C18D038
6401 Holly Avenue

**HYDROLOGY DEVELOPMENT SECTION
DEVELOPMENT REVIEW BOARD MEMO**

**RE: Dr. Bernitsky Eye Care Facility
6401 Holly Avenue NE**

Re: Dr. Bernitsky Eye Facility, Engineer's Stamp dated 10-16-07 (C18/D38)

PROJECT NO:
COPYRIGHT AKT ARCHITECTS, LLC
SHEET TITLE
GRADING/DRAINAGE
PLAN

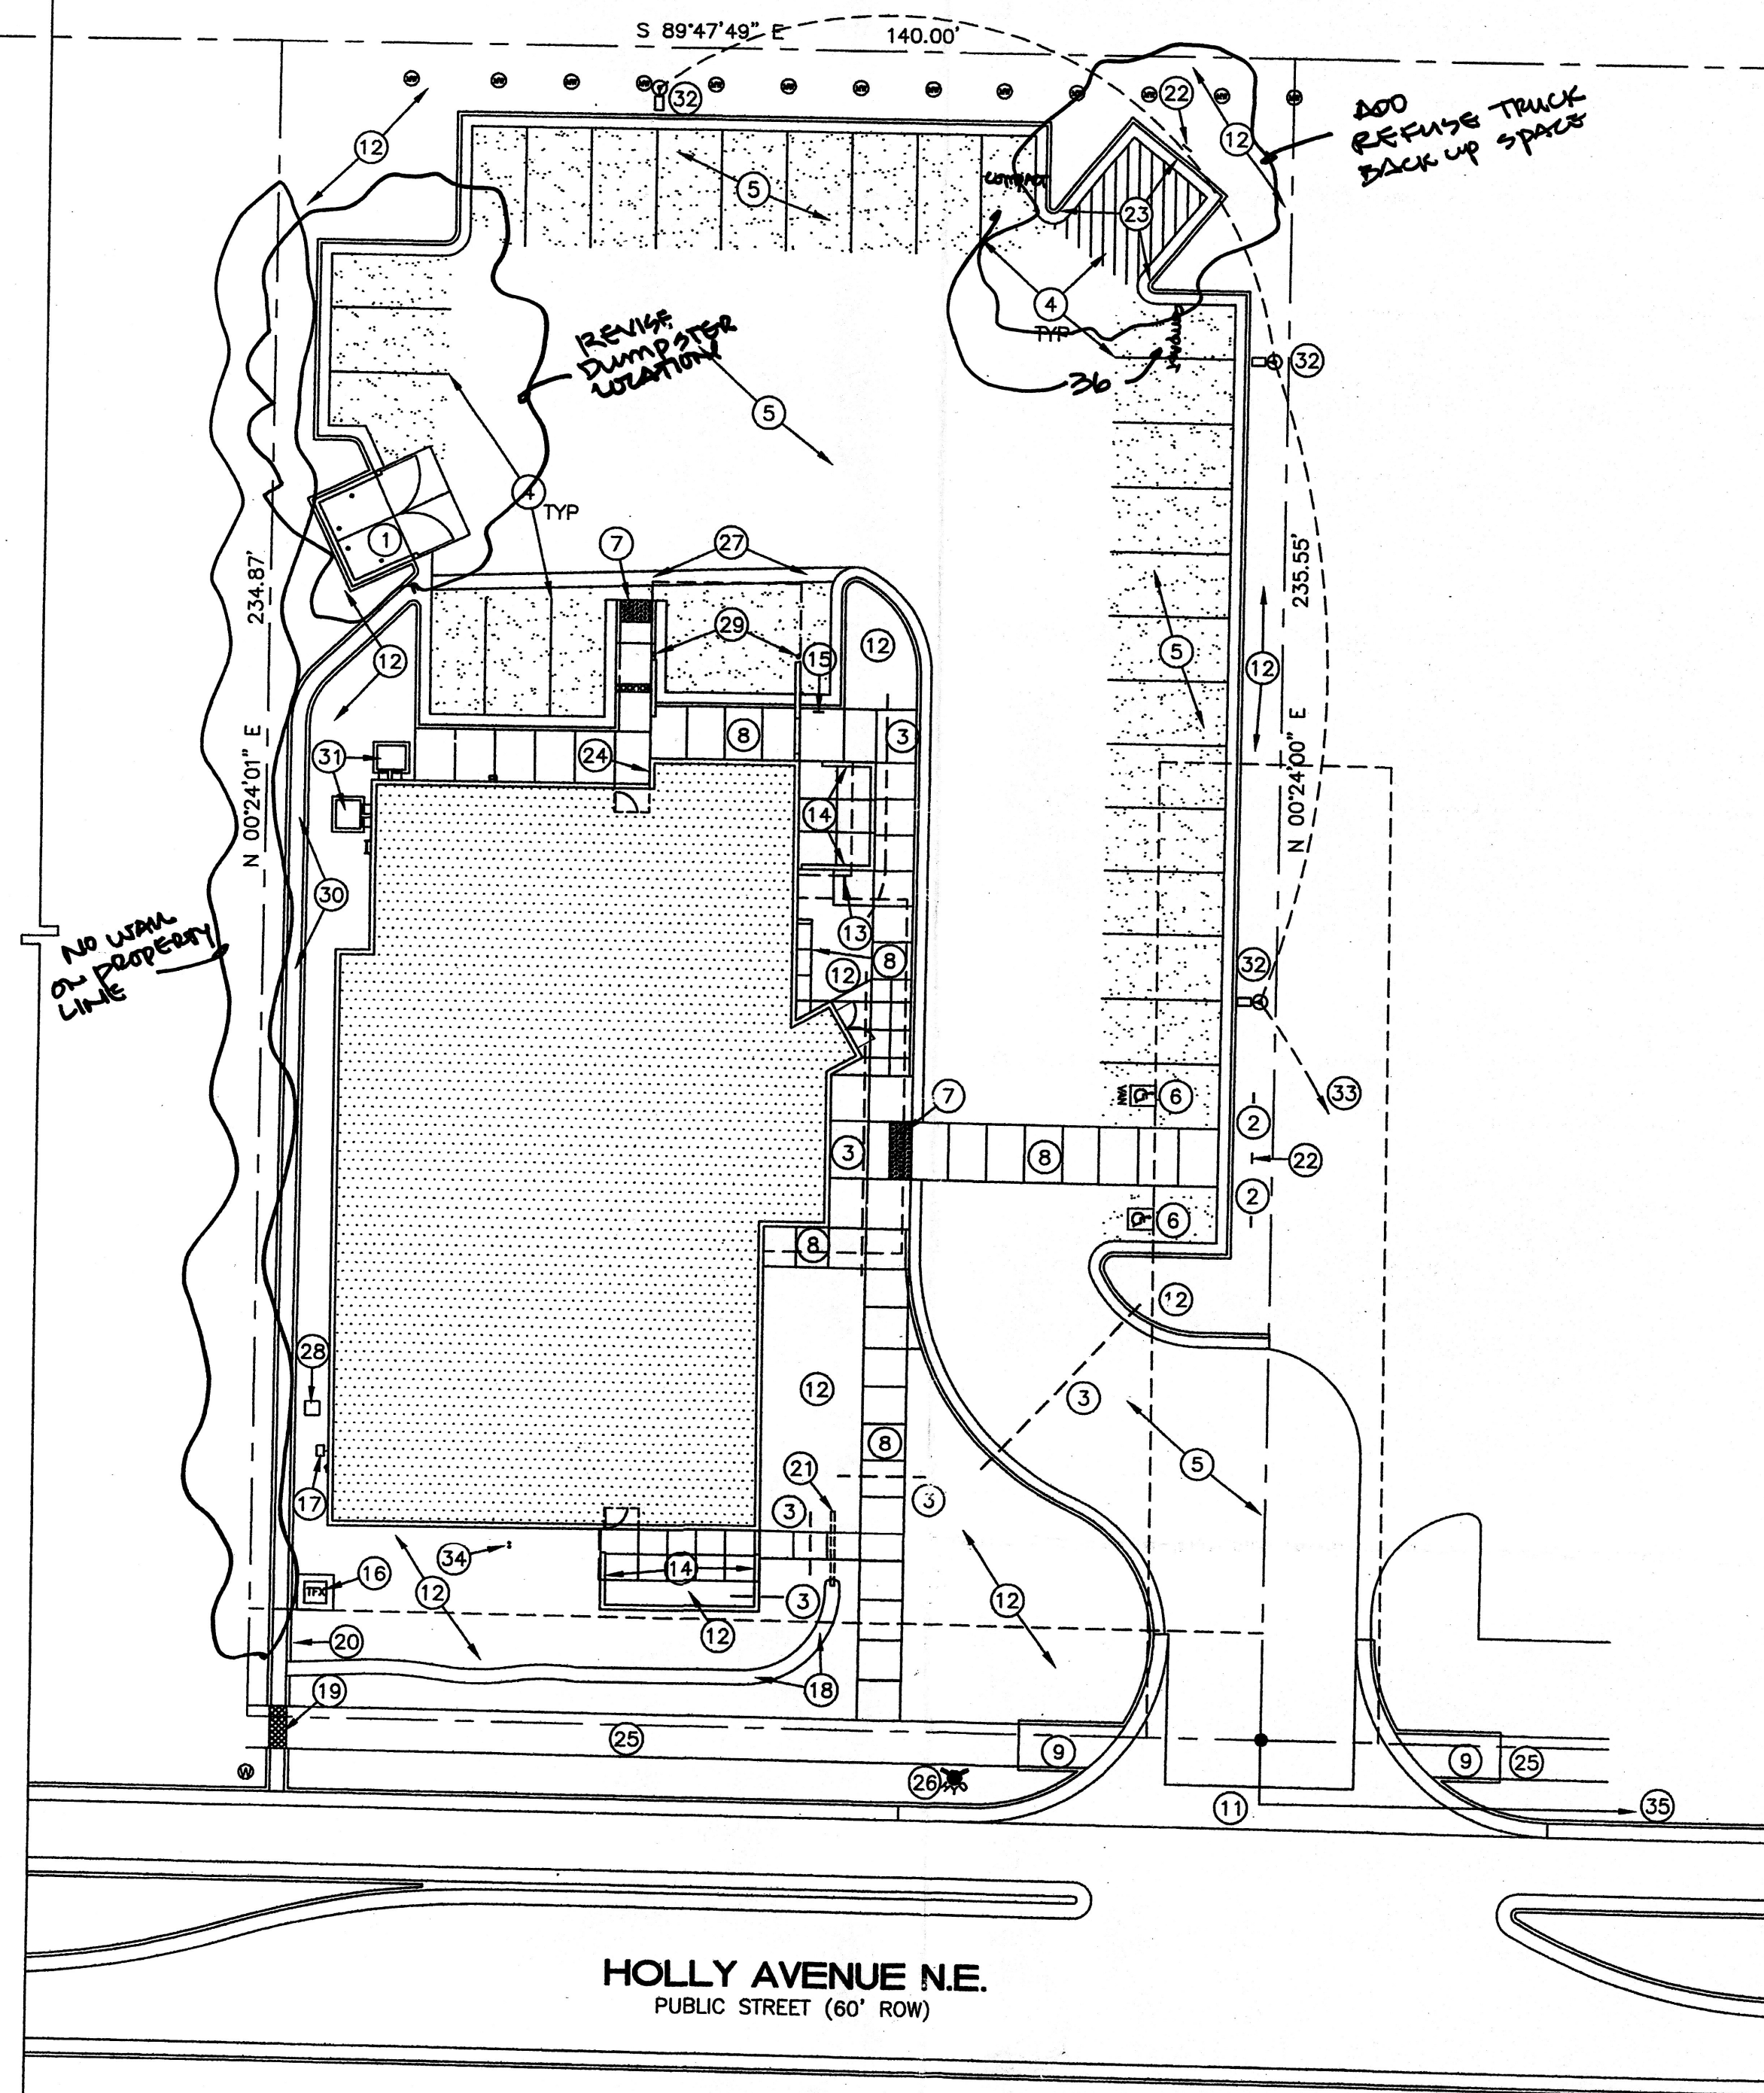
- Records indicate the presence of an existing storm drain located at the northwest corner of the site leading north to Calle Avion. Your plan gives no indication of its presence. Has it been removed? Has there been any investigation as to its existence or lack thereof? Was the associated 35-foot easement vacated? Please verify and show on the plan.

The records indicated the presence of a storm drain inlet and line that lead north into Calle Avion. The site contained a land fill that was removed and remediated under the Supervision of Lawrence Earth engineering and the imported fill and associated compaction was documented by Vineyard and Associates. The survey that was provided to us for this project showed the old alignment of the storm drainage line but no pipe existed on site due to the massive earthwork operations required to remove the landfill up to 25' deep on the north end of the site. I am not certain about the questions regarding the vacation of the easement. The survey that was provided made no mention of an easement.
